Re: Harborview Heights – Technical Review 2  
SP23-007

After reviewing the application materials for the above referenced proposal, the following technical review comments are provided:

HARBOR VIEW HEIGHTS
 SHORT PLAT
 NUMBER SP23-007

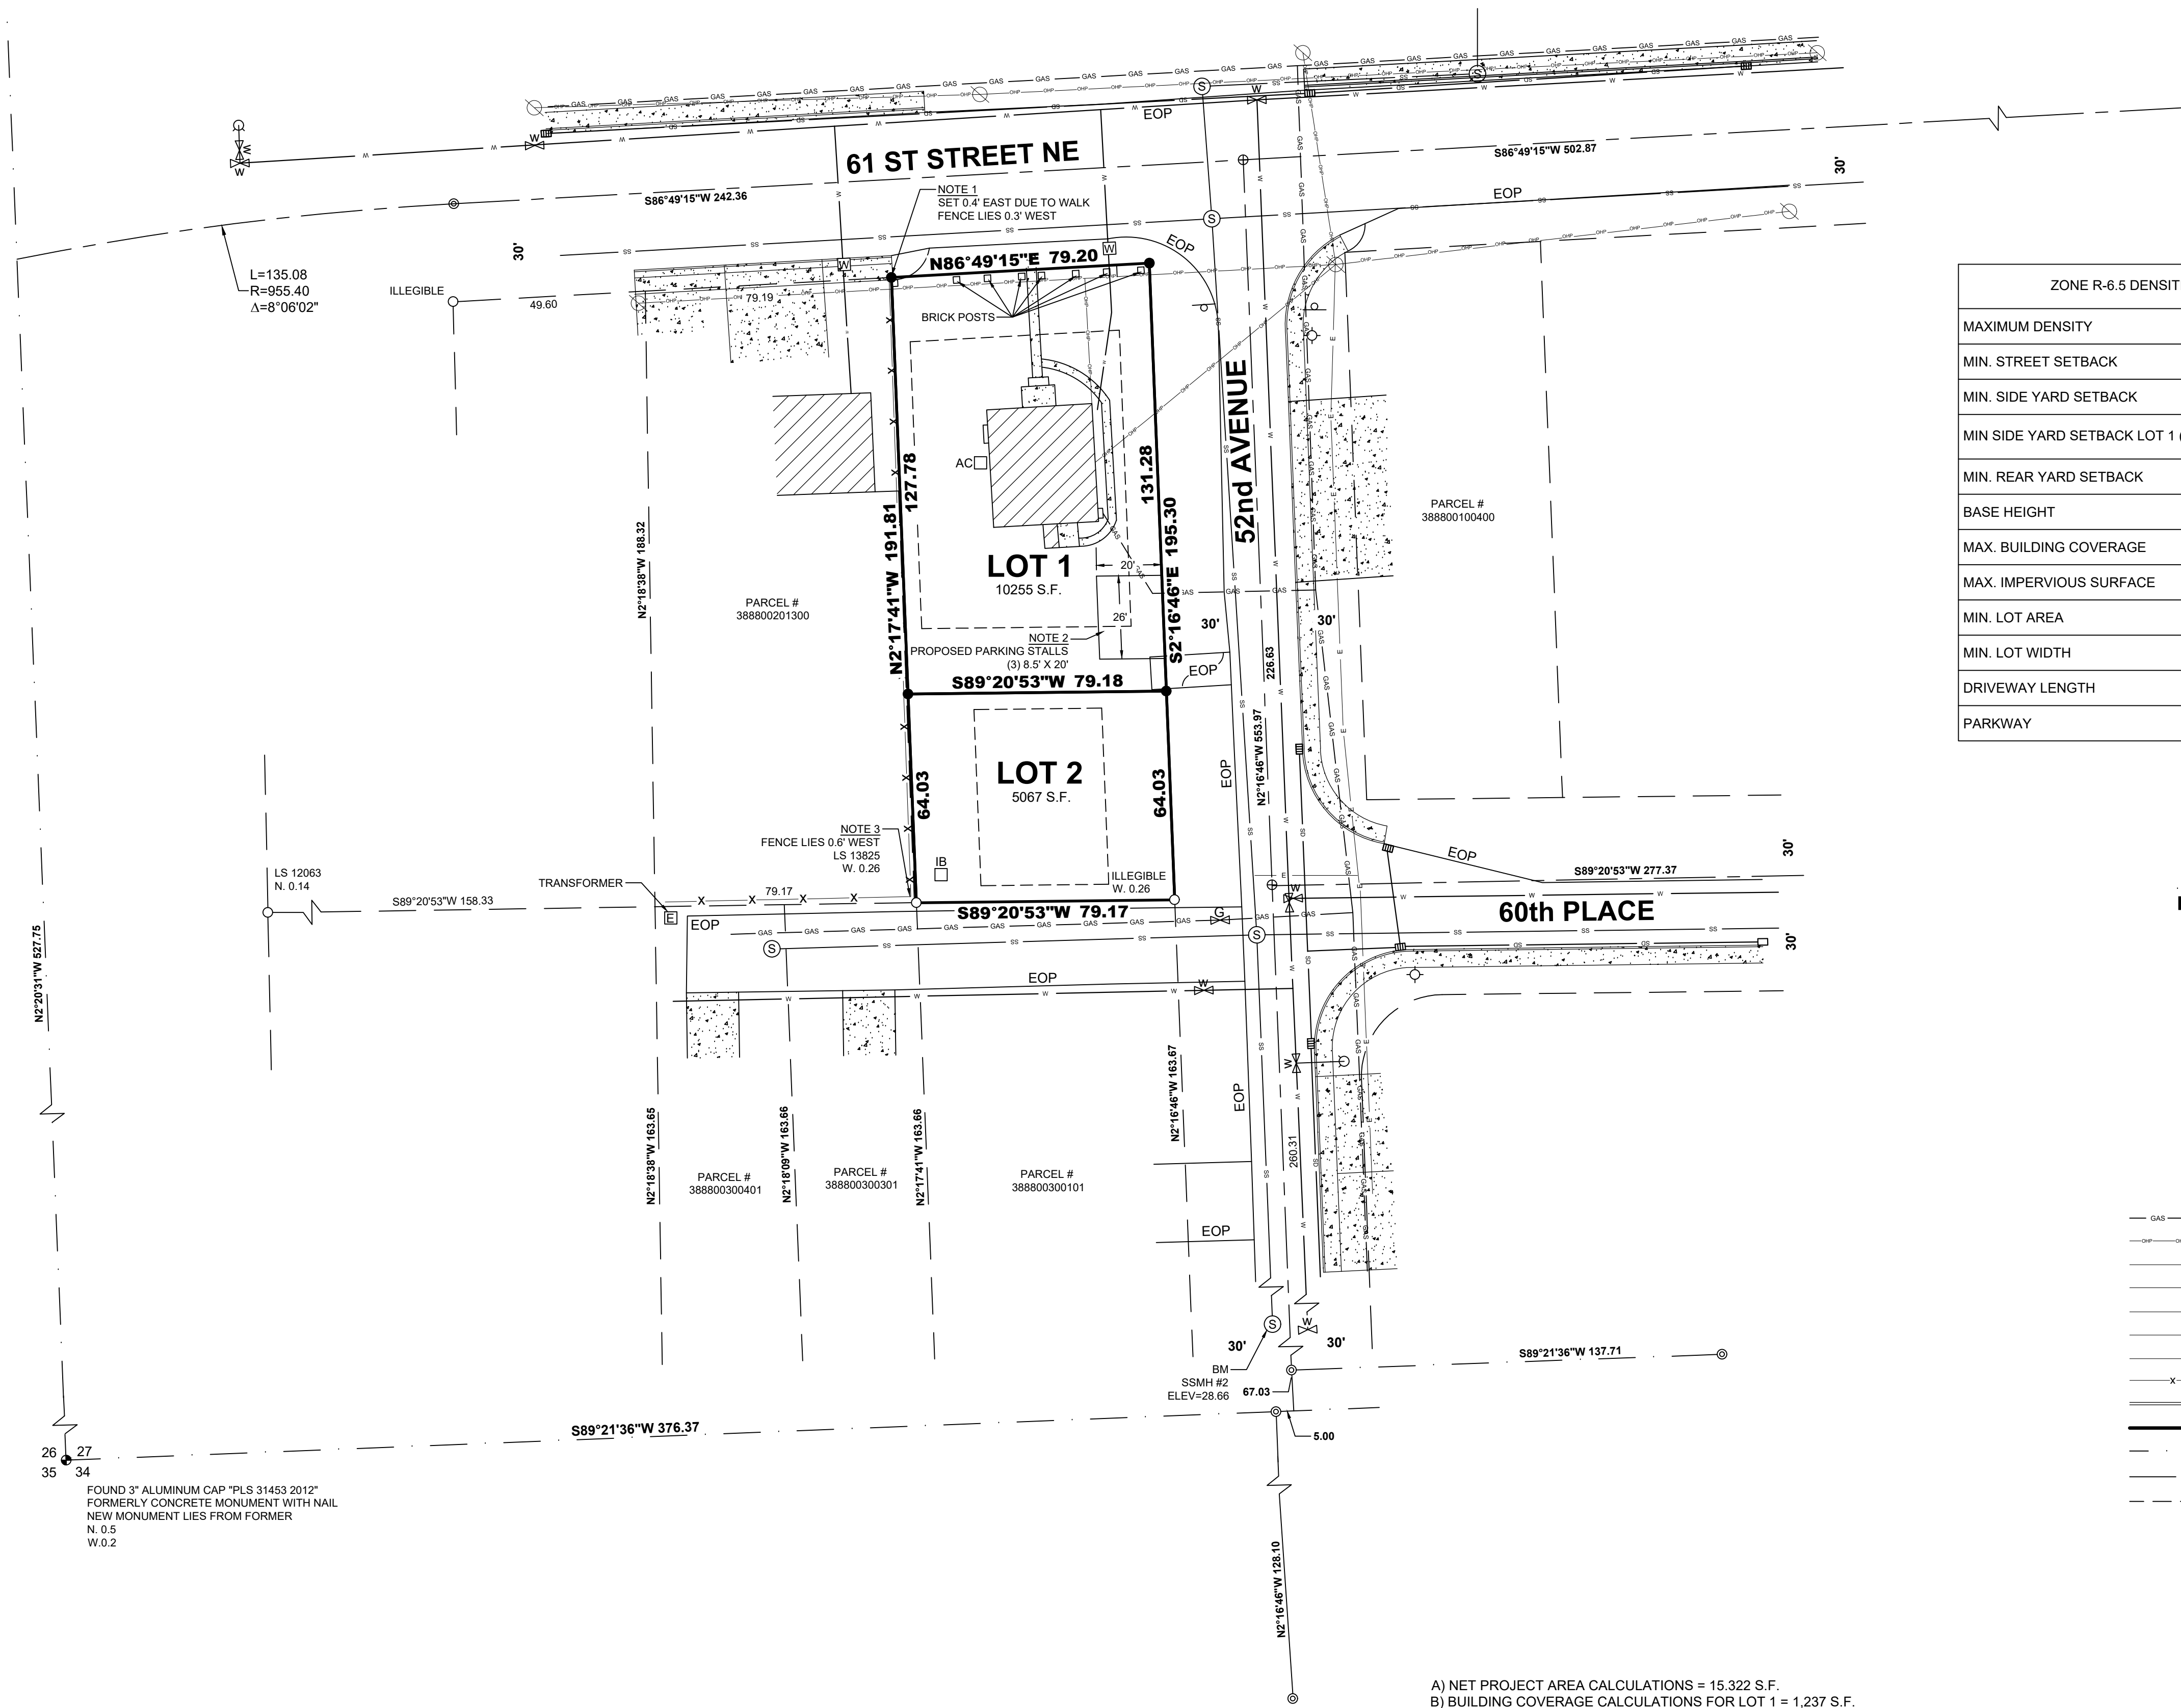
1. **TR1 Comment:** Show the following setback lines on the preliminary short plat map:
  - a. Lot 1:
    - i. Front yard 20ft
    - ii. Rear yard 20ft
    - iii. Side yard (52<sup>nd</sup> Ave) 10ft
    - iv. Side yard (west) 5ft
  - b. Lot 2:
    - i. Front yard 20ft
    - ii. Rear yard 20ft
    - iii. Side yards 5ft

**TR2 Comment:** Setback lines have not been provided on the preliminary short plat map.

2. **TR1 Comment:** Amend the preliminary short plat map to include the following:
  - a. Net project area calculations (see definition in [MMC 22A.020.150](#))
  - b. Building Coverage calculations for lot 1
  - c. Impervious surface calculations for lot 1 (see definition in [MMC 22A.020.100](#))

**TR2 Comment:** Calculations for net project areas, building coverage and impervious surface coverage have not provided on preliminary short plat map.

**TR1 Response:** Setbacks are shown on the plat map.

**TR1 Response:** Table has been included on the plat map.
